Subject: LU/261/18/PL - Request for additional information

North Elevation (To River Road).

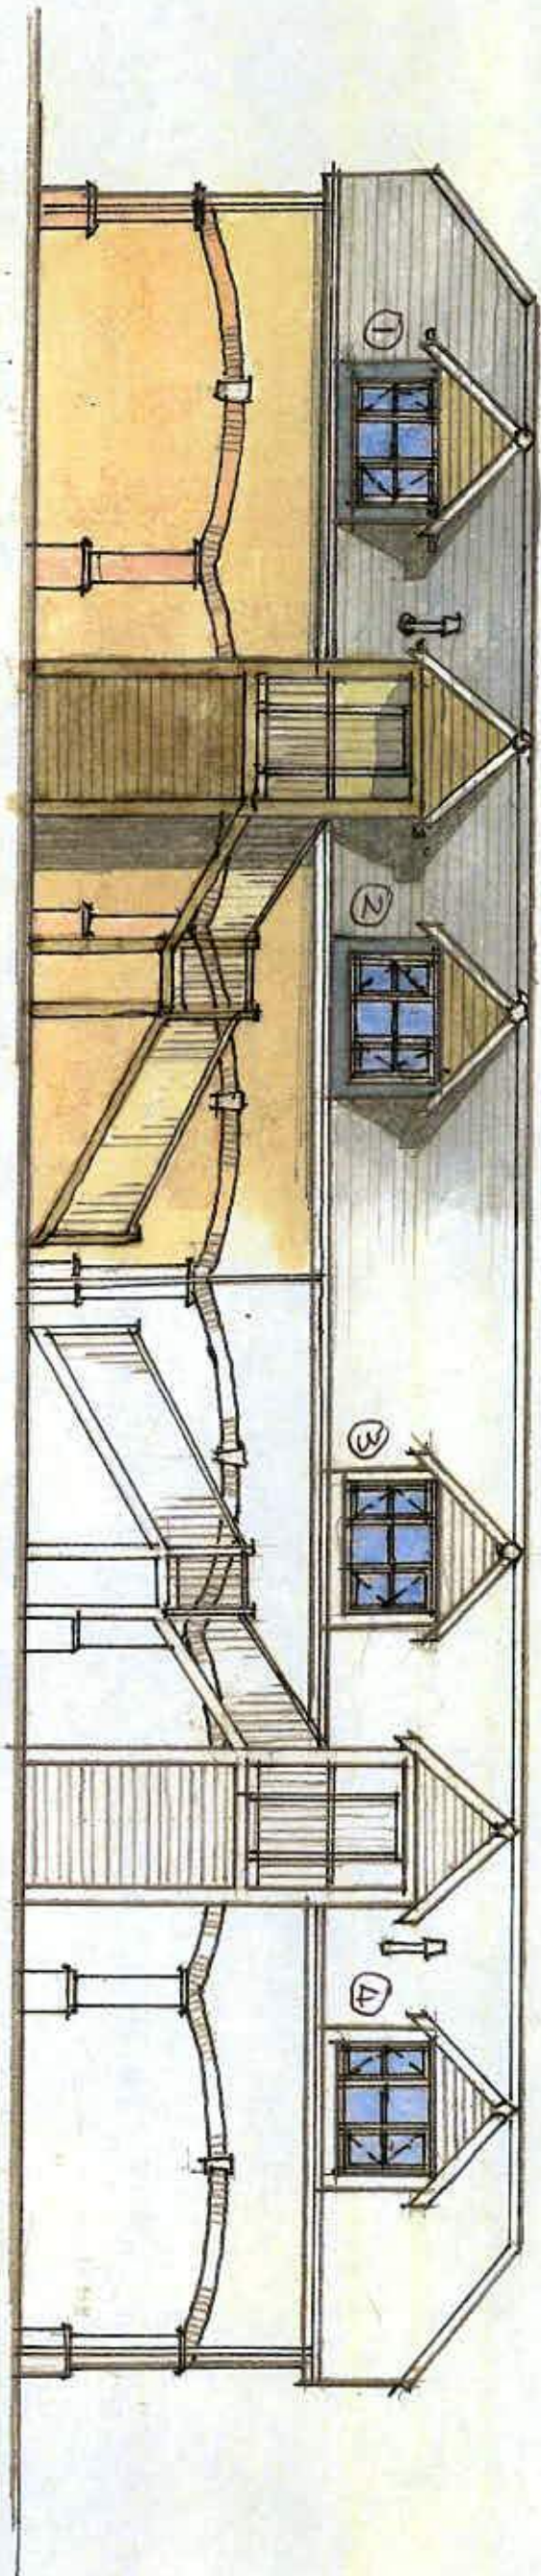
Following a discussion with The Council's Conservation Officer, I was wondering if you could submit further details of the window design? This should include layout of glazing bars, how thick these bars will be, how thick the frames will be etc.
